PROPOSED CARE HOME DEVELOPMENT - 22/03452/F

OS PARCEL 6920 - EAST OF OXFORD ROAD AND ADJOINING AND SOUTH OF CANAL LANE, BODICOTE.

TECHNICAL NOTE 1 – REPLY TO OXFORDSHIRE COUNTY COUNCIL CONSULTATION RESPONSE DATED 21ST DEC 2022.

11TH JANUARY 2023

FIG 21 – PROPOSED SITE PLAN

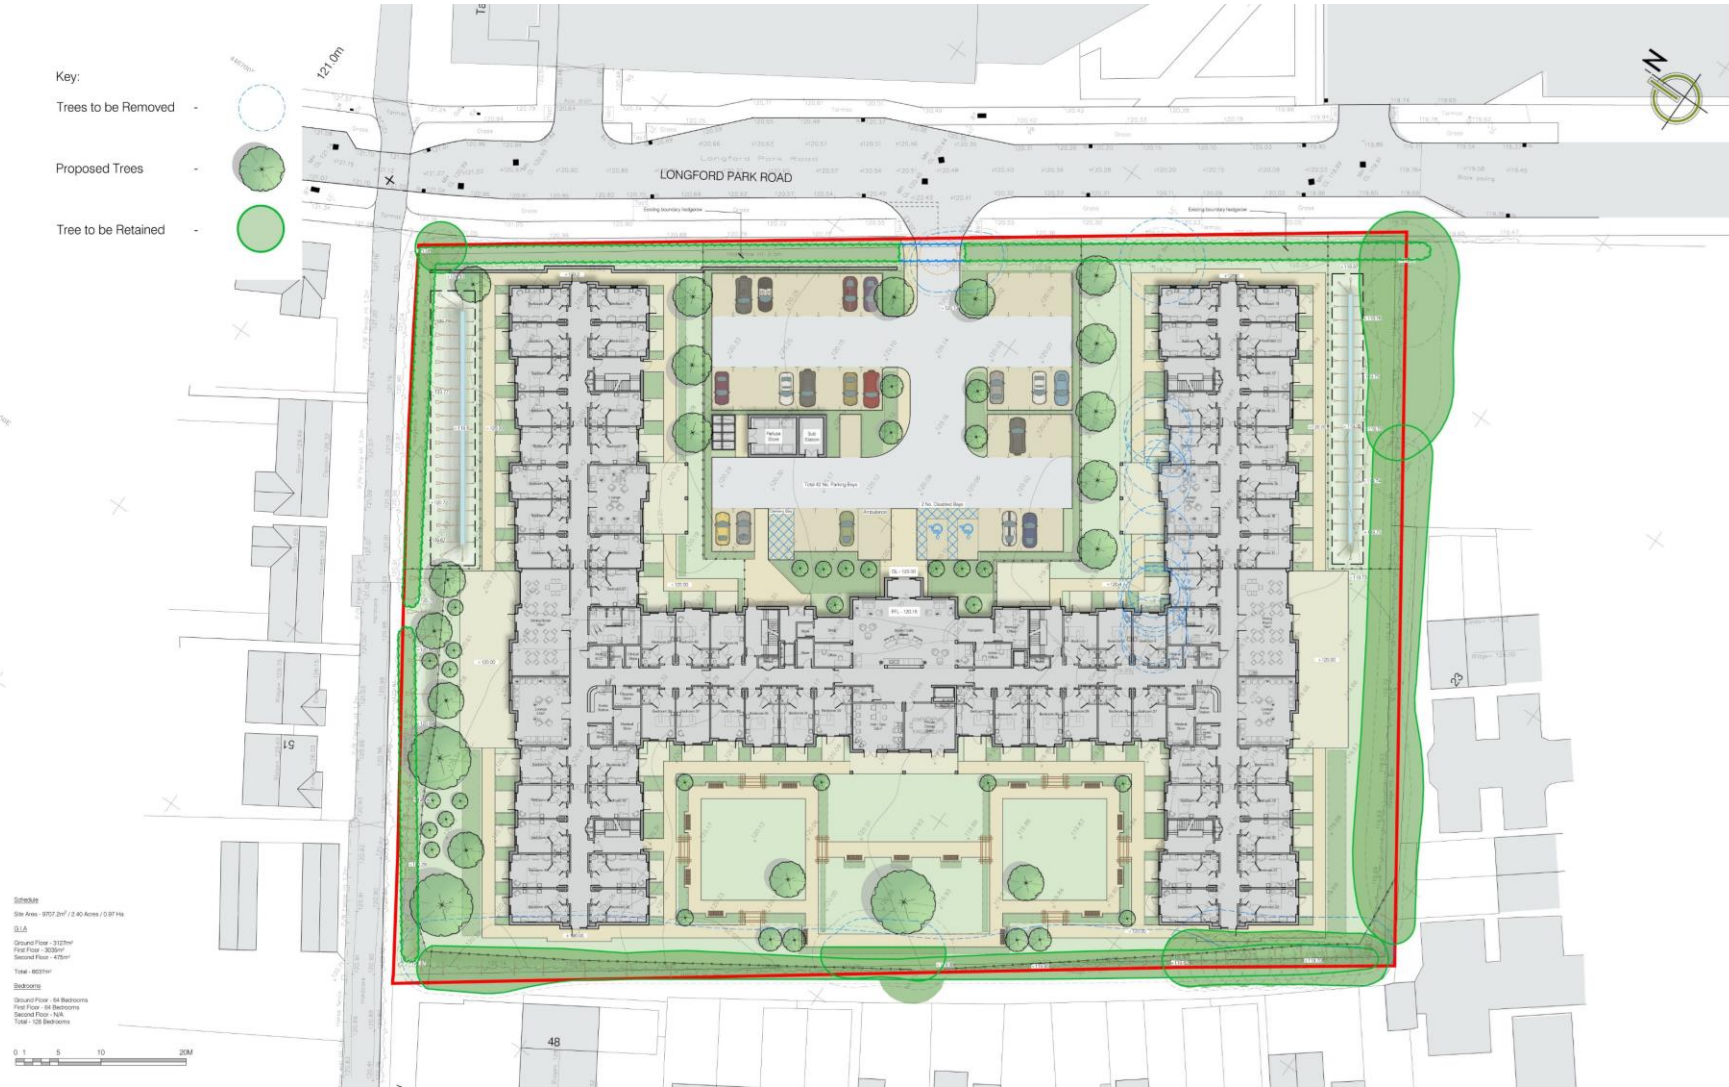
- The development does not provide safe and suitable access for all users as required under the NPPF. A section of footway is required on the southern side of the site access in order to provide refuge for pedestrians leaving the site and heading south, reducing the risk of conflict with vehicles turning into the site.

From the access junction, along the short access road, there is a footway on the northern side but nothing on the southern side. I consider that a section of footway is also required on the southern side of the access road in order to provide refuge for pedestrians leaving the site and looking to head south, who would otherwise likely be walking in the access road carriageway. This would reduce the potential for conflict between pedestrians leaving the site and vehicles turning in. I consider this particularly important given the increased likelihood of pedestrians using walking aides. **Objection**

The planning documents make no reference to the provision of EV parking infrastructure at the development and it appears from the layout plans that no EV charging spaces are proposed. The adopted Oxfordshire Electric Vehicle Infrastructure Strategy and OCC Parking Standards set out that a provision of 25% of all spaces for new employment developments are required to have EV charging infrastructure.

The application documents set out that a total of 10 covered cycle parking spaces are proposed. This is significantly below the level set out in the OCC Parking Standards for residential care homes, which is at a ratio of 0.5 spaces per bedroom with spaces to be available for residents, visitors and staff.

The cycle parking is currently shown as being located directly adjacent to the bin store. This is not ideal for encouraging cycling, especially during the summer months. I would request therefore that the location of the cycle parking be reconsidered.

- 2.2 The revised site layout plan at **Appendix 2** shows five electric car parking spaces equating to provision at 12.5%. These electric spaces will be active spaces, fully operational from the day of opening. 15 Passive electric space will also be provided.

- 3.2 The proposed site layout plan at **Appendix 2** has been amended and a section of footway on the southern side of the site access, immediately adjacent to Longford Park Road been incorporated into the design.

- 4.2 OCC guidance indicates that 0.5 cycle spaces should be provided per bed. This would equate to 64 cycle spaces accommodated via 32 Sheffield style strands. This is considered to be grossly excessive.

- 4.8 A total of 10 cycle parking spaces are being provided; this allows for a substantial amount of growth in cycling were it to materialise via the travel plan, or if the occupier has a high level of cycle use outright. Cycle use can also be monitored via the Travel Plan, reported to the local authority as part of monitoring process and the level of cycle parking increased as necessary.
